WEST SUSSEX COUNTY COUNCIL  
INFRASTRUCTURE CONSULTATION

SUBJECT: BR/276/08

4 Tennyson Road, Bognor Regis

Construction of 1x3 bedroom house on land adjacent to 4 Tennyson Road

SITE PLAN

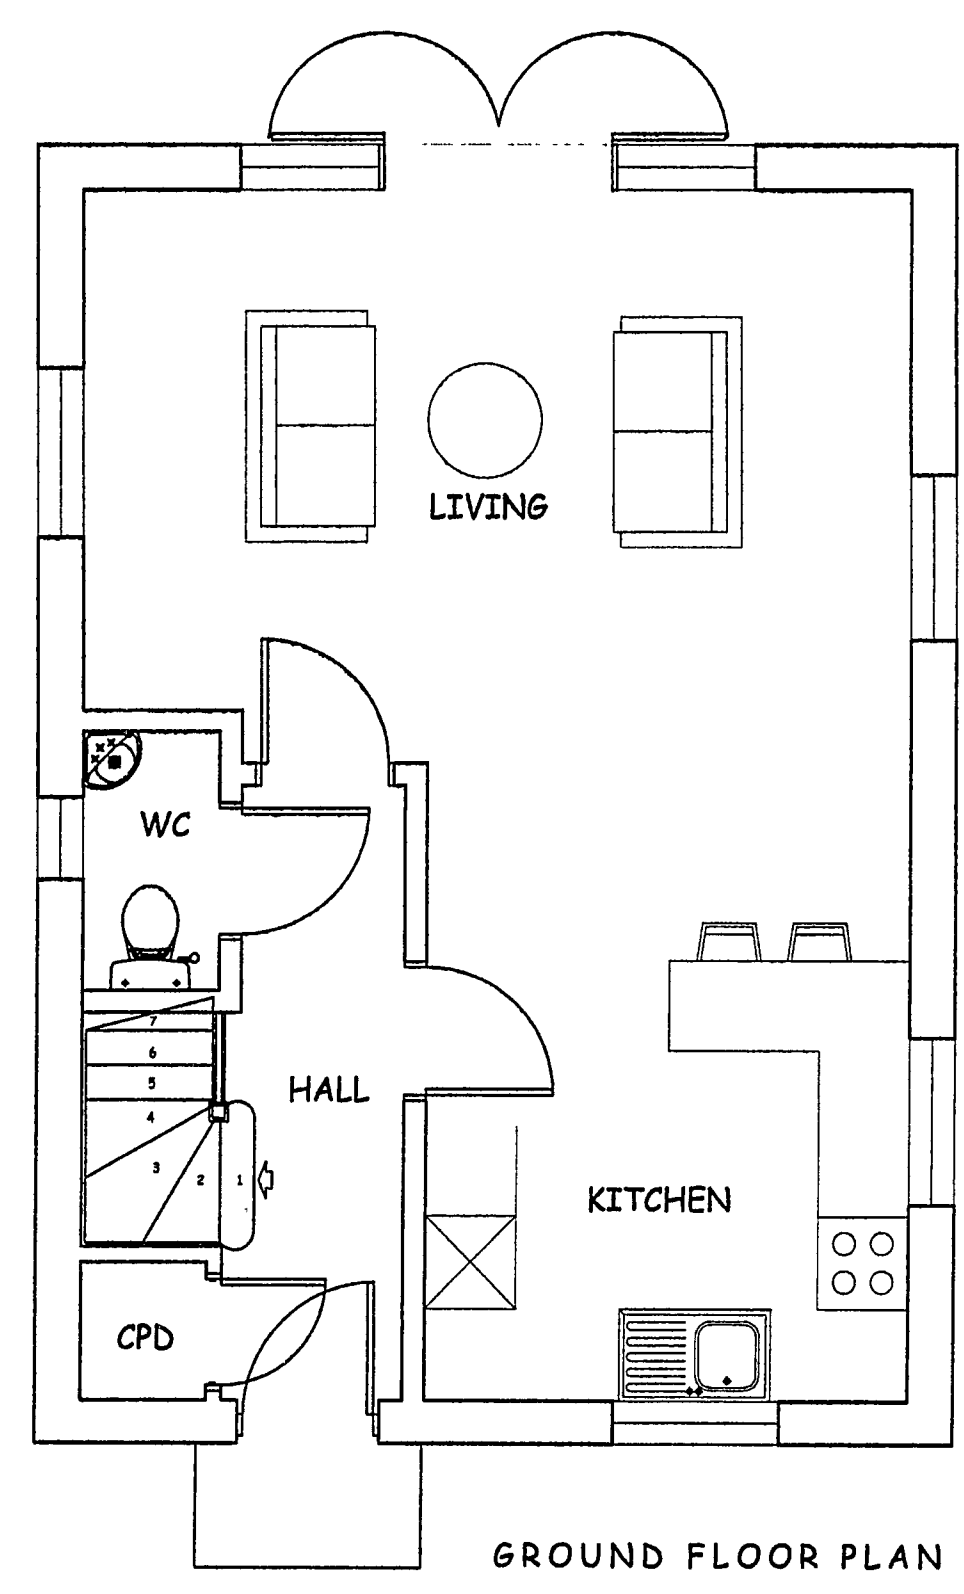
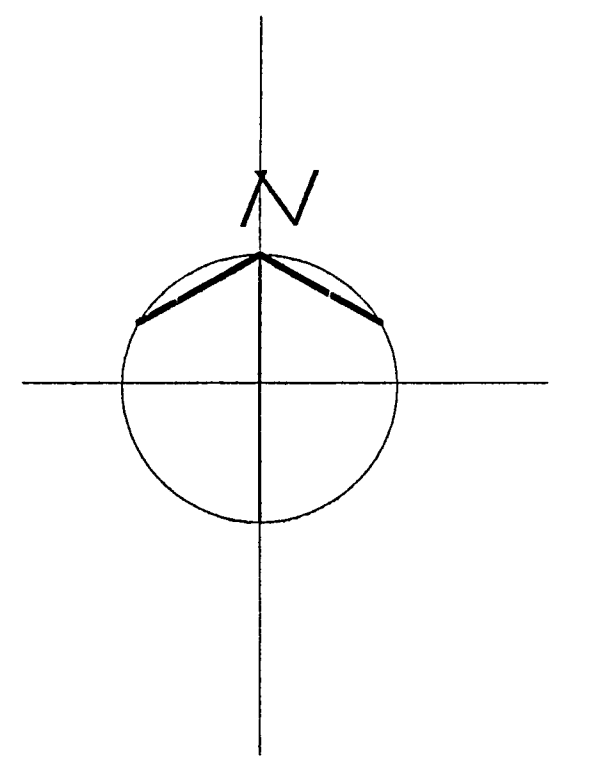
The proposal is for a single dwelling unit with access onto Tennyson Road via a new access point. This proposal has been considered using plans submitted with this application, in conjunction with other available map information. A site visit can be arranged on request.

From an inspection of the plans alone, there is no apparent visibility issue at the point of access onto Tennyson Road. We have also checked our most recently available verified accident records, which reveal there have been no personal injury accidents in the vicinity of the existing point of access, indicating a low risk of highway safety issues with this proposal. The applicant is advised that in order for the proposed access to be constructed as planned it is possible that existing street lighting would need to be moved, for which the applicant would need to meet the costs of. Any plans to move street lighting would need to be agreed with WSCC prior to any access being formed, and Richard Bird would be the point of contact for such agreements.

No development of the site shall commence until the vehicular access serving the proposed dwelling has been constructed in accordance with the approved drawing.
